From: Phil Brown [redacted]
Sent: 26 September 2019 07:30
To: Maria Tomalova <[redacted]>
Cc: Caroline Gosford [redacted]
Subject: FW: BR/120/19/PL & BR/121/19/L, The Bandstand

From: Maria Tomalova <[REDACTED]>
Sent: 02 August 2019 18:53
To: Phil Brown <[REDACTED]>
Subject: BR/120/19/PL & BR/121/19/L, The Bandstand

Essentially, the proposal is to repair the structure, whilst restoring certain elements and generally refurbishing it. I note from the Design and Access and Heritage Statement that the existing general layout of the site would be retained. The access into the bandstand would be altered slightly with the pedestrian gate relocated from the south elevation to the west elevation, and the two open sides to the east and west infilled with new balustrading to match existing. The existing step on the west elevation will be retained.

REV	DESCRIPTION	DATE
PROJECT BOGNOR REGIS BANDSTAND THE ESPLANADE BOGNOR REGIS WEST SUSSEX		
DRAWING TITLE REFLECTED CEILING PLAN AND LIGHTING PLAN

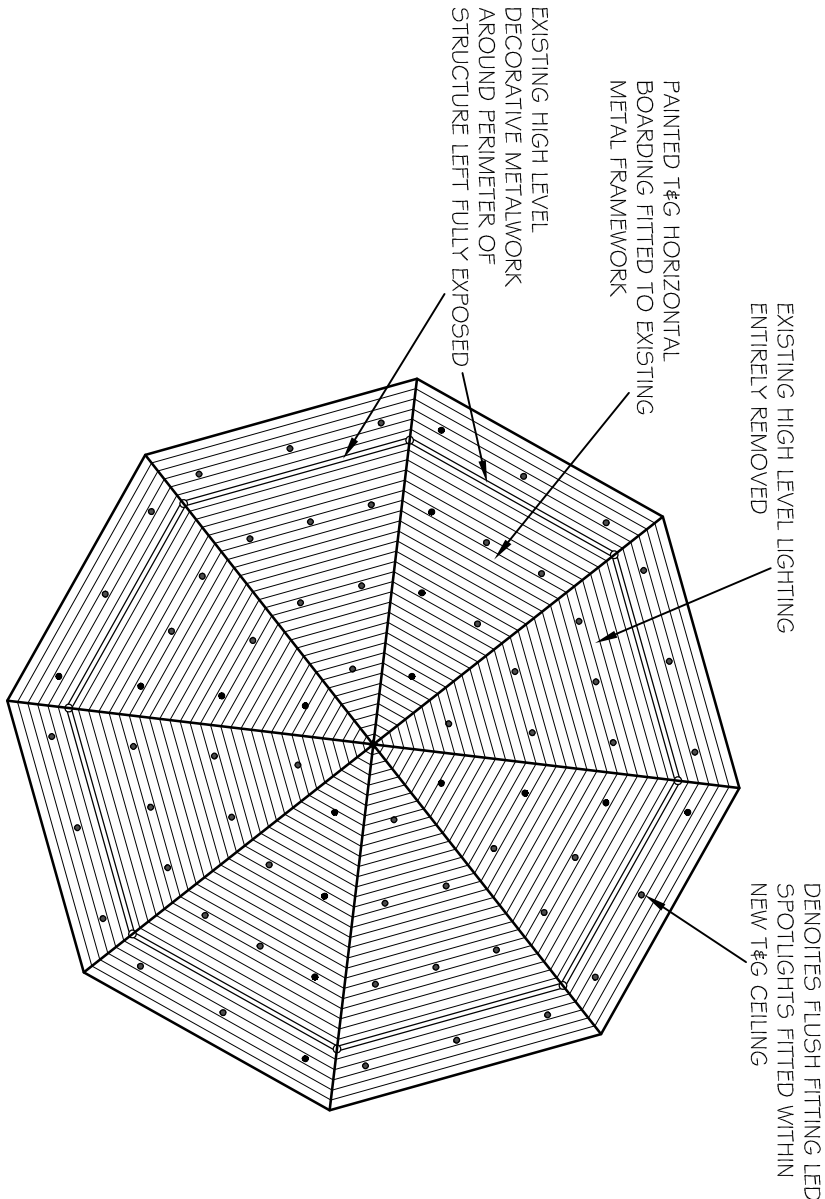
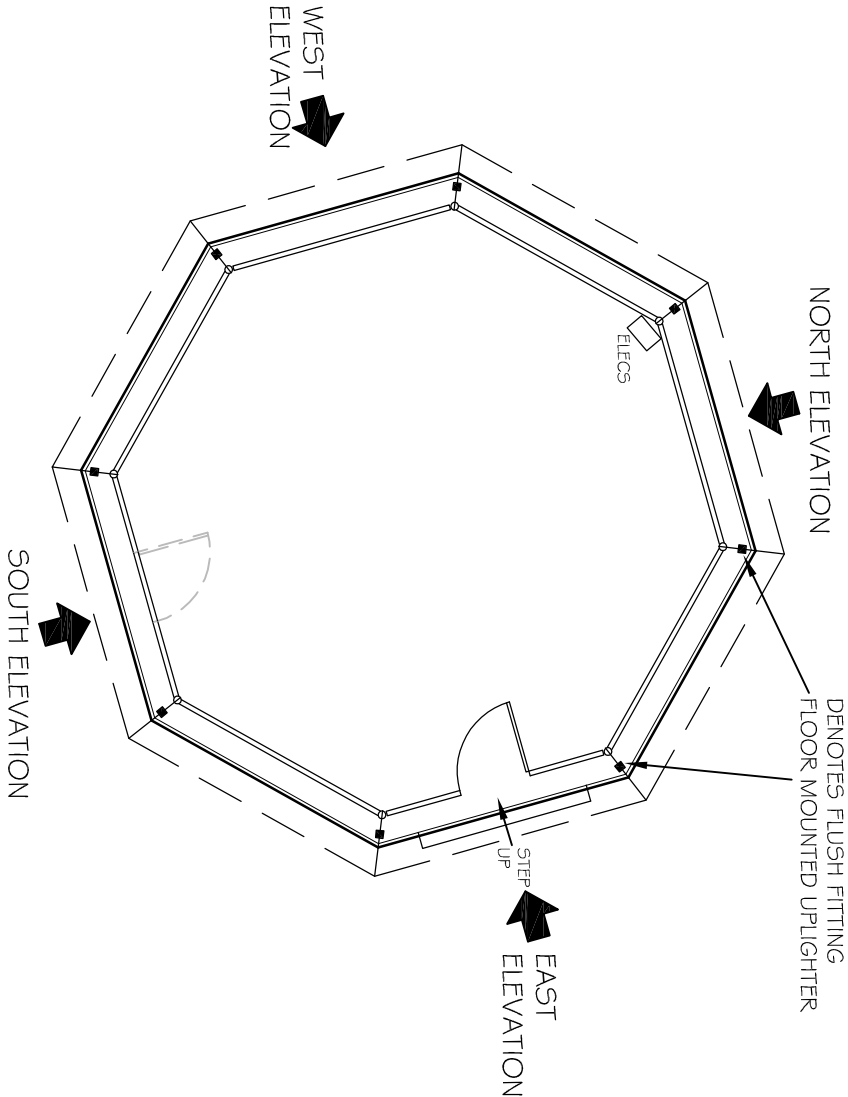
Also how will the horizontal timber boarding to be fitted below the roof structure to form a ceiling be treated?

- **Timber ceiling boarding.** The new timber boarding will be fitted to existing horizontal metal framework and would have a painted finish.
- **Materials.** We accept that a suitably worded condition will need to be applied to agree the details of the new bricks and other items.

DWG NO 824/04

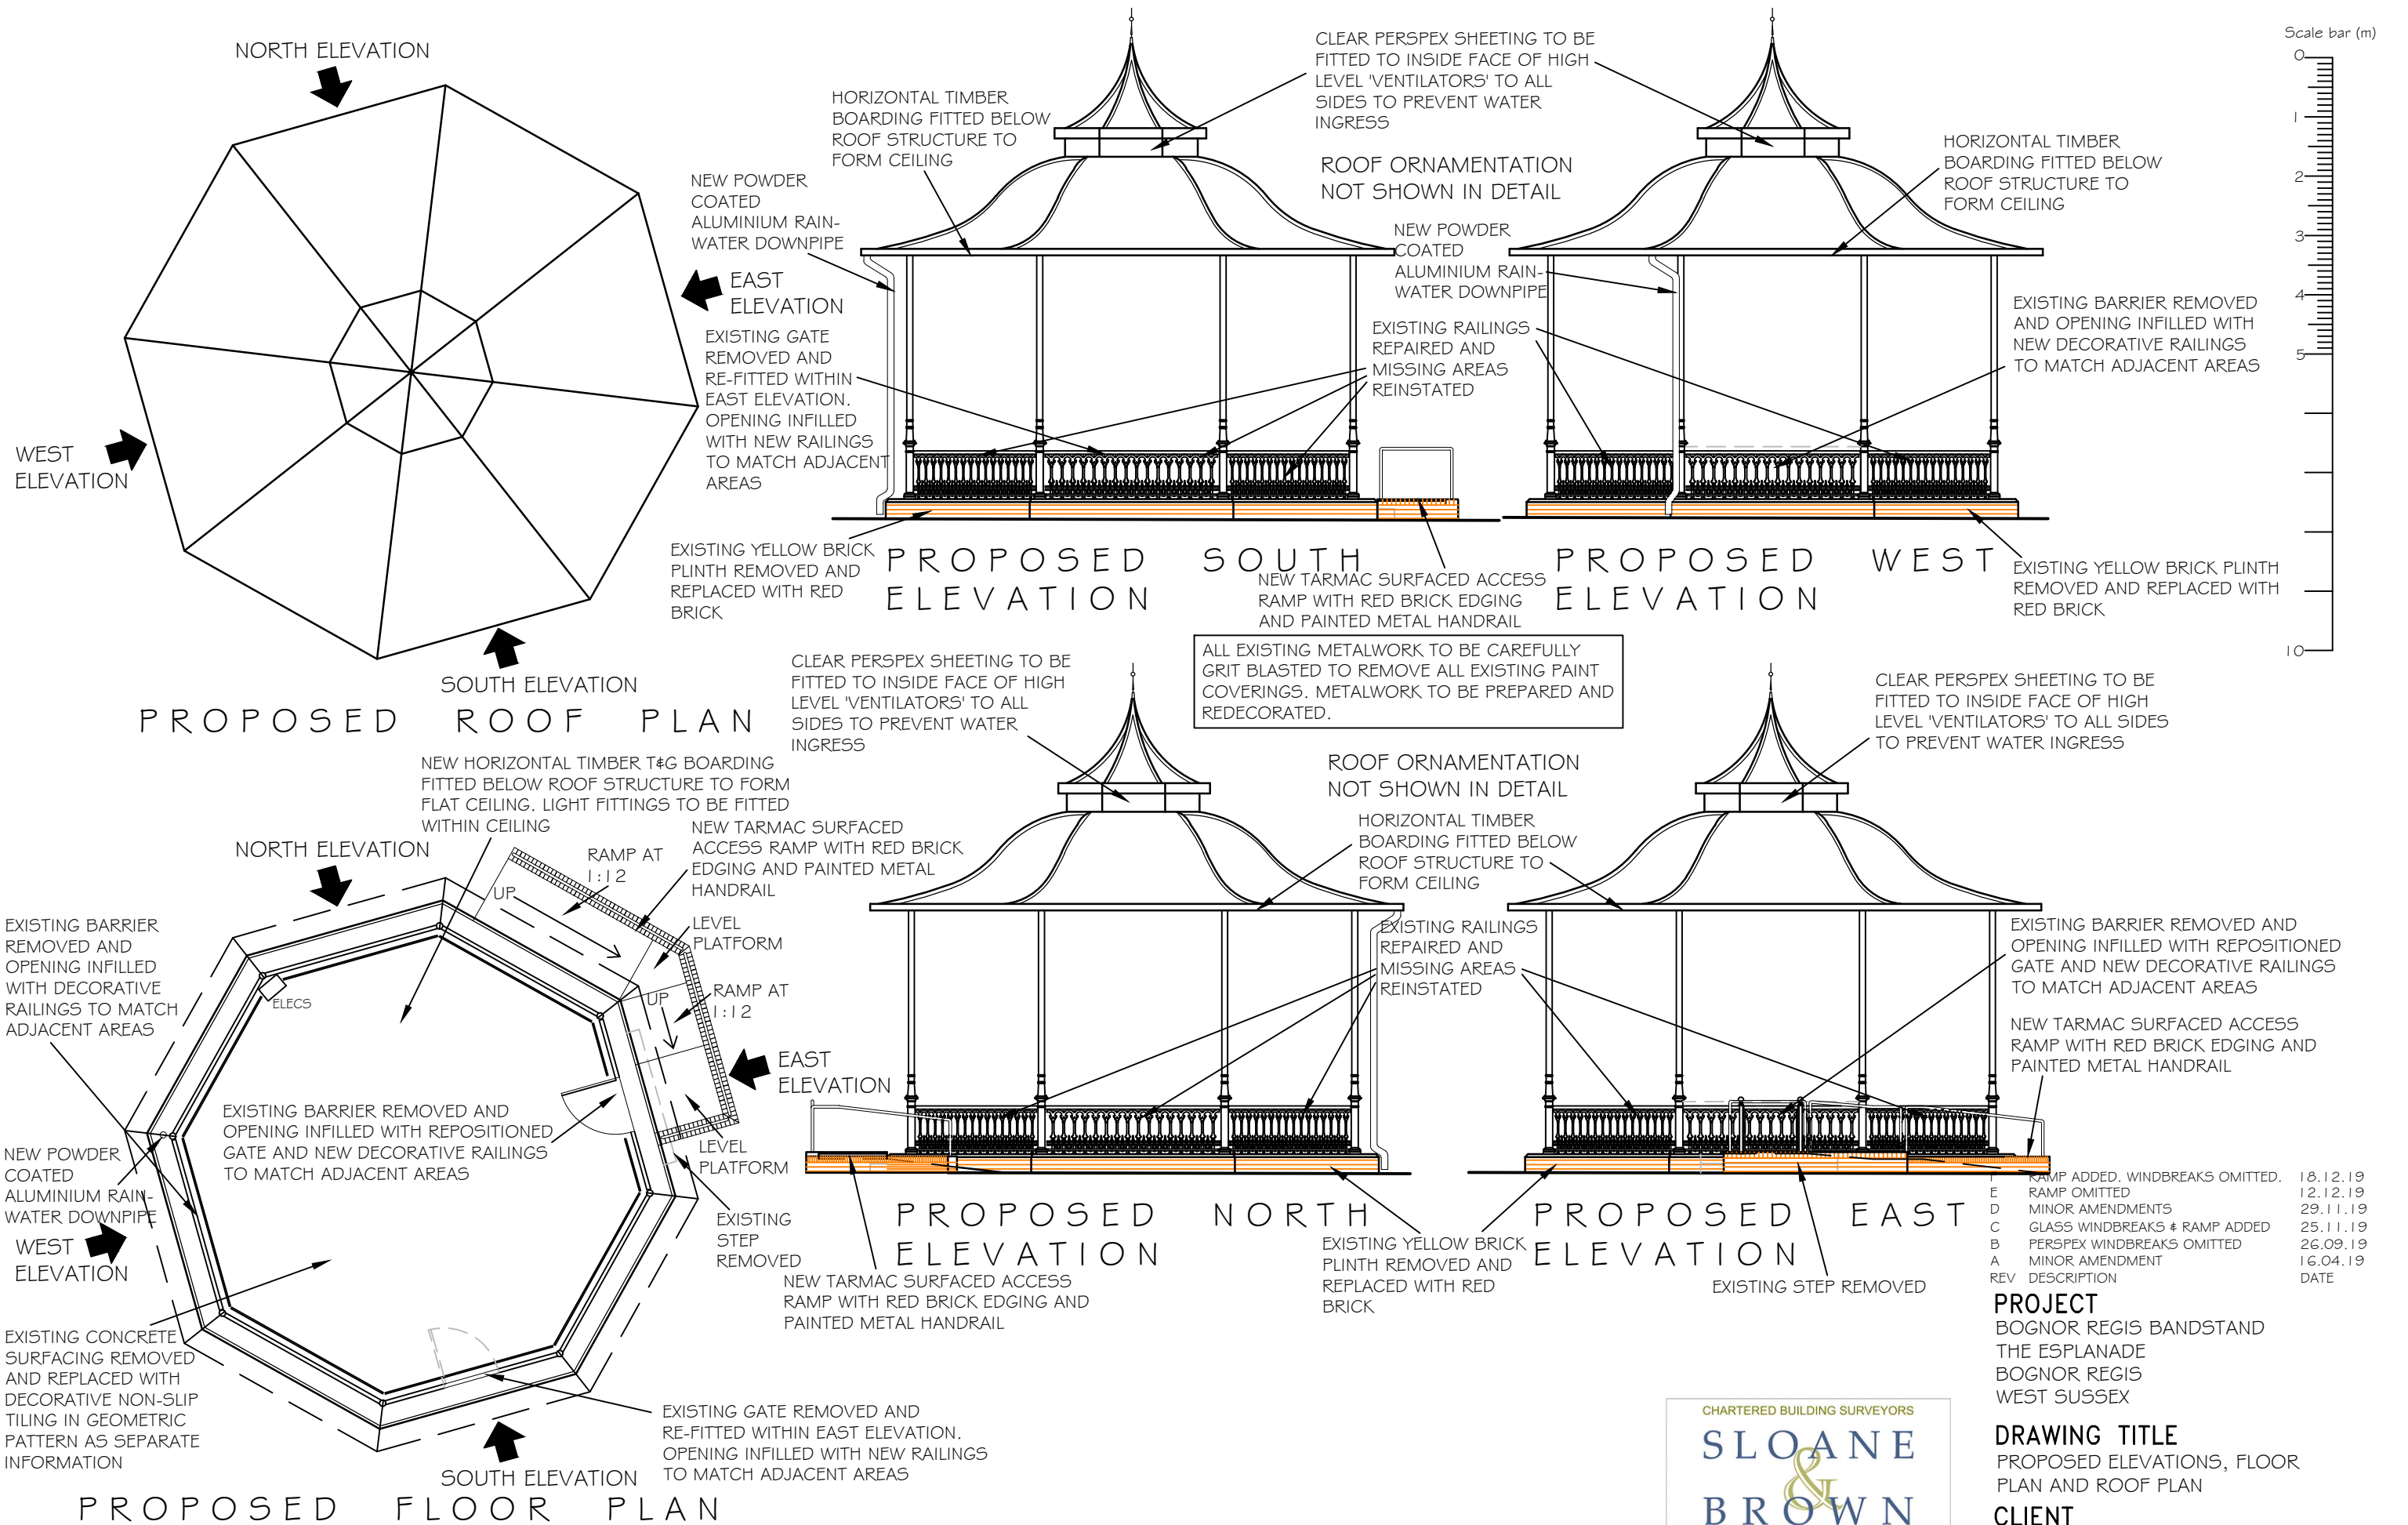
However, there are some issues which require clarification. It is not clear from reviewing the information why the location of the gate is to change.

Further, scant information has been provided regarding the proposed Perspex sheeting; how will it be fixed to the structure? Will it form a permanent element of the structure, or will it be used on a temporary basis (and removed when not required)? Further, what size will the panels be? What would the quality of the materials used be? At present, such an issue is considered to be problematic.

Please find attached drawing 824-04B which now omits the previously proposed Perspex sheeting to the railings which would have formed windbreaks.

I can confirm the proposed Perspex sheeting at high level has been retained within the proposals. This will be fitted on the inside face of the existing metal fretwork and is required to prevent water penetration into the structure. The new Perspex sheeting will not be readily visible and would be potentially easily removable on a future occasion in order that the work can be fully reversed.

- **Relocation of access gate.** The Bandstand has previously been disassembled and re-assembled and is not in its original location. There is no particular historic or architectural significance related to the current positioning of the access gate except that it faces directly onto the seafront. The balustrading and handrail (and associated access gate) are relatively interchangeable between the main structural support posts as the structure is a regular, symmetrical shape. The relocation of the gate will position it where there is currently an access step, which would seem an entirely logical location as this position would enable easy access and egress without disturbing the main thoroughfare along the promenade.

- **Perspex sheeting.** This will be secured on the internal face of the metal railing with simple ties of metal wiring. This will mean there would not be any fixing into the existing structure and will enable easy removal and re-fixing as required. It is anticipated that the sheeting will be in place on a relatively permanent basis to provide some protection from the weather from people seated within the bandstand. This sheeting will enable the bandstand to be used on a frequent basis as a viable use for a seating area. However, the sheeting could be fairly quickly and easily removed and replaced as required due to the simple nature of the fixings. The panels will be clear, frameless panels fitted to a height just below the handrail and would fully fill the width between each of the main structural posts. The structure including the metal railings will be clearly visible through the proposed panels, and accordingly there would not be any negative impact on the visual qualities of the structure. When The Bandstand was in its original location in Cheltenham it was fitted with glass panels (as noted in the Heritage Statement) but these were not re-fitted when it was relocated to Bognor Regis. We trust this information will also help to satisfy the concerns raised by the Town Council.
